Precinct Village and Car Park

Value Management package

Sydney Football Stadium Redevelopment Design Integrity Panel Presentation

Minutes of the Precinct Village and Car Park VM Design Presentation held on Monday 6 December 2021 via Microsoft Teams.

1 WEST ELEVATION (PLAZA)
SCALE 1:250

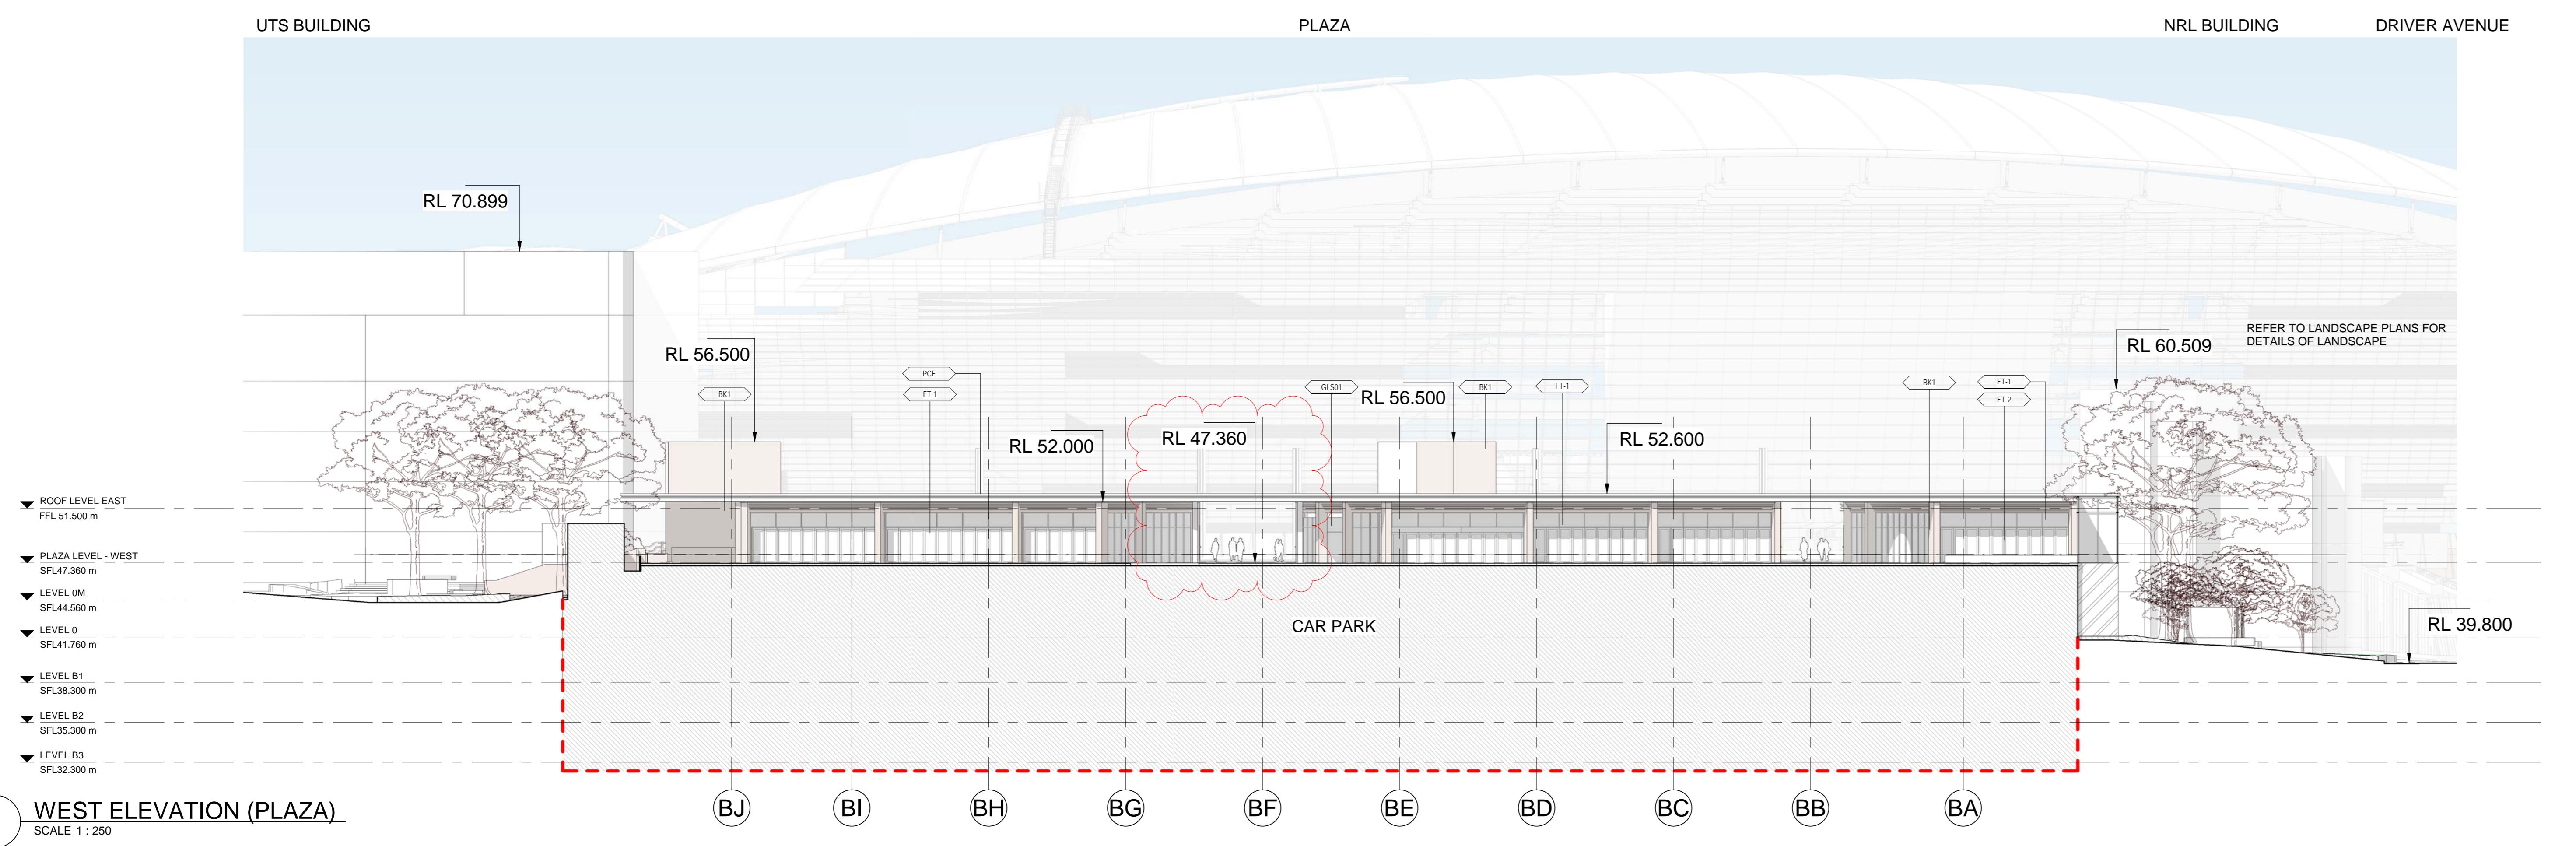
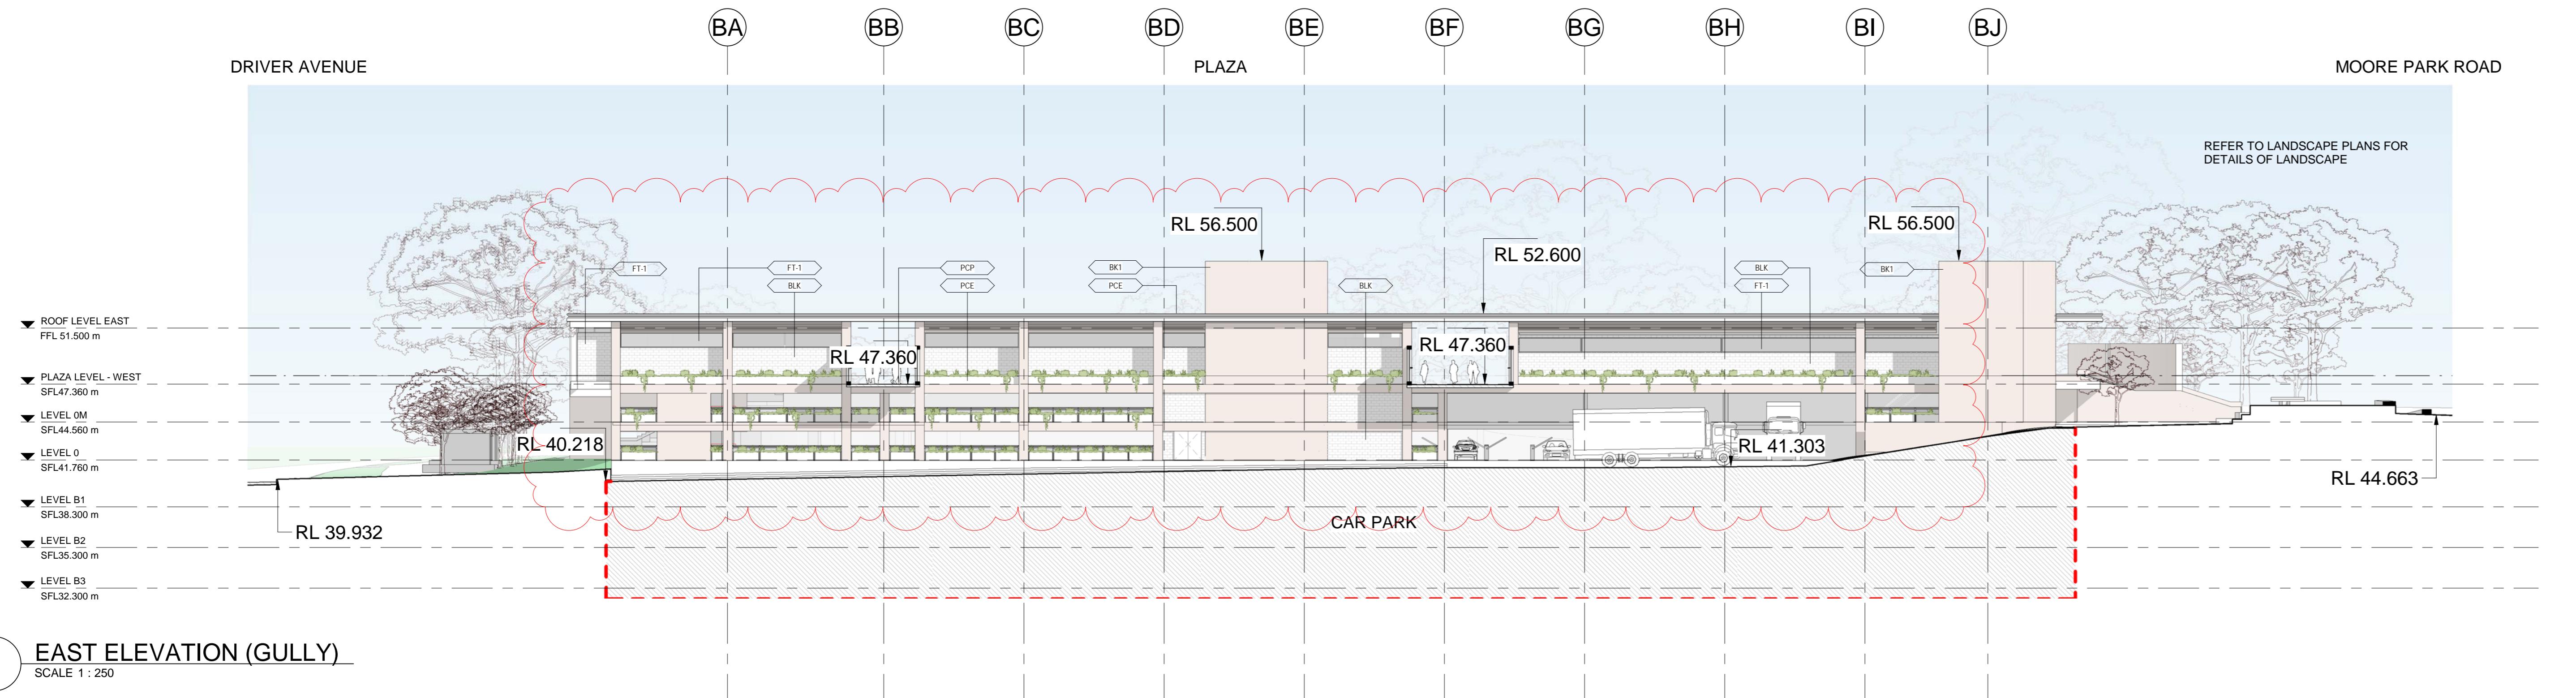
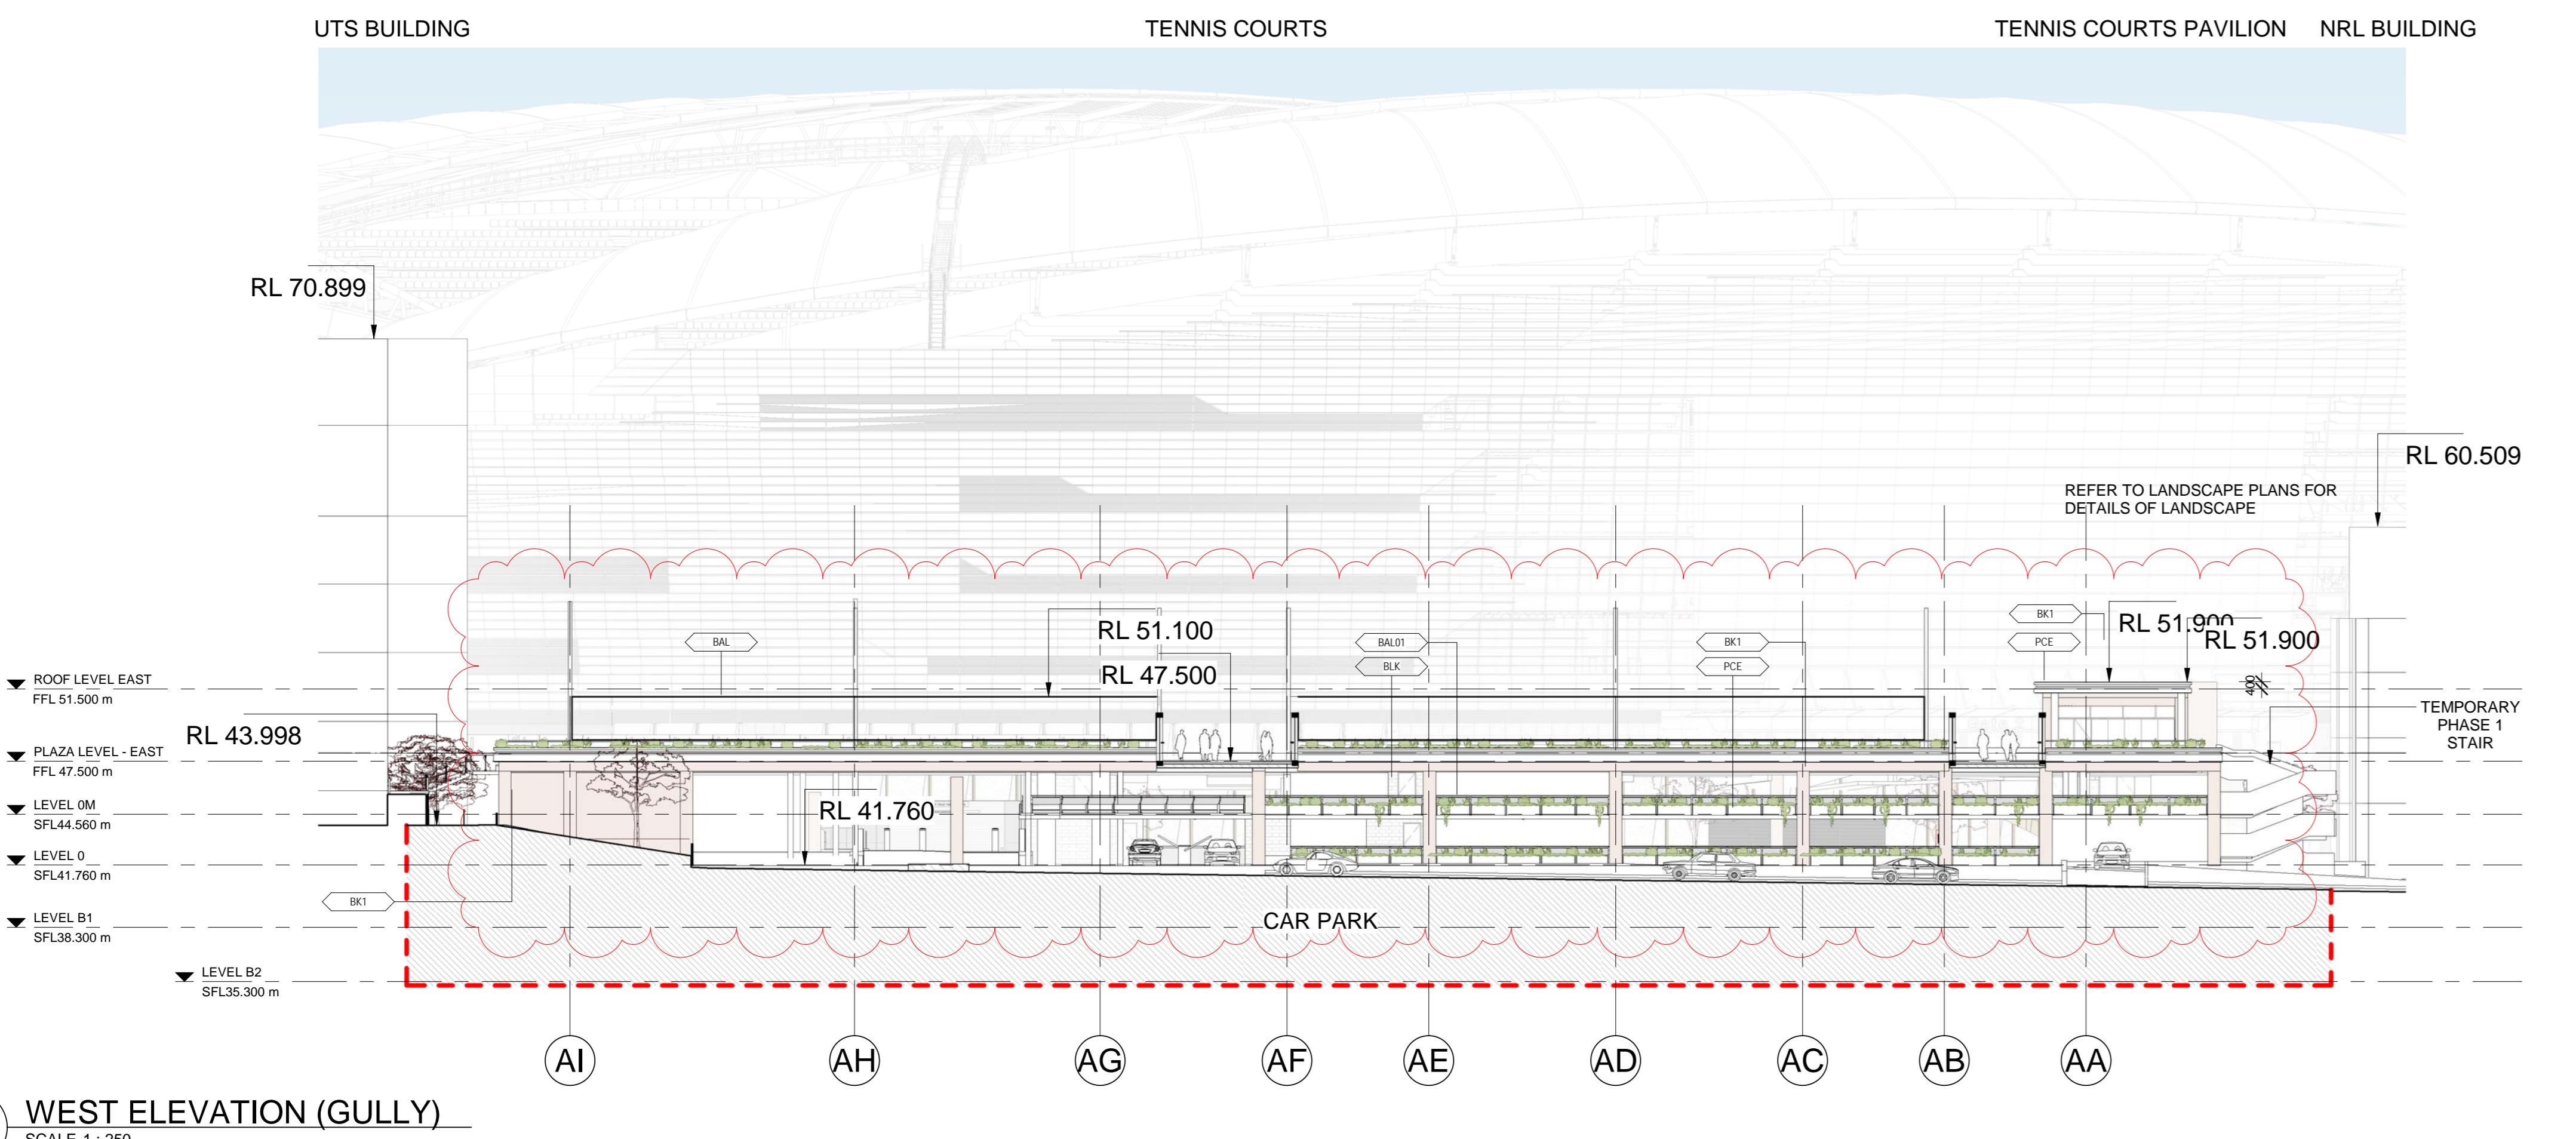
- KC queried whether the SSDA submission option with “hit & miss” brickwork required the crash barrier or guard rail to be added. AY/JA confirmed that the guard rail is required as the guard rails replace the original in-situ planters which are proposed to be lightweight GRC planters in the proposed alternative option. AY/JA further note that screens or other forms of barriers are required to stop both people from falling and vehicles, and both planter boxes and softwalls are not high enough for the purpose of preventing people from falling, requiring guard rails to all elevations.

- KC queried the cost savings with the replacing the “hit & miss” brickwork and in-situ concrete planters with lightweight GRC planters, galvanized steel balustrade with perforated metal infill and crash barriers. MM estimated the cost savings is approximately \$300,000.

- PP queried if all the “hit & miss” brickwork and the planter boxes are to be removed in the option. AY confirmed the planter boxes to the south and east façade are to be removed, but planter boxes on the gulley are to be maintained but replaced with the lightweight GRC planter boxes. AY further confirmed that vehicle barriers and guard rails are still required where planter boxes are used.

- KC queried if use of guard rails with the GRC planter boxes could be interspersed with some retained “hit & miss” brickwork and if this would be a cost neutral option. JA confirmed this is not a cost neutral option. KC noted the response. JA further confirmed the

- KC noted that the changes need to be the best application of saving versus retaining a strong design intent particularly to façade elements.
- TG queried who will see the changes to the carpark façade in the option. AY confirmed on the south and the east side will be the most evident locations, and the west design is still maintaining the green softening and the brick as much as possible.

- TG noted that the retention of the brick portal frames does retain the connectivity with the SCG brick walls to Driver Avenue. TG further noted that there are potential issues with the “hit & miss” brickwork as it would require further development to include guard rails etc. SJ further noted that the “hit & miss” brickwork was also potentially climbable and would require additional screens.

- PP noted that there could be further investigations with regards to the landscaping details to dial up the landscaping to these elevations within the GRC planters to soften the façade.

- KC agreed and further noted that the hit and miss brickwork is not really fit for purpose so the team need to look at a more sophisticated landscape with the proposed option. Further that provisioning for installation of fabric awnings should be investigated to be added to the tennis club building if it will provide weather protection, simplification of the roof planting with PVs is supported.

-
- TG summarised and the DIP concurred that the removal of the “hit & miss” brickwork would be supported noting that Aspect Studios would need to refine the landscape design to the planters to ensure that it softens the facade. It was further discussed that investigation of stainless steel mesh and vines be undertaken. Aspect should advise best fit for landscape screening and on-going maintenance,
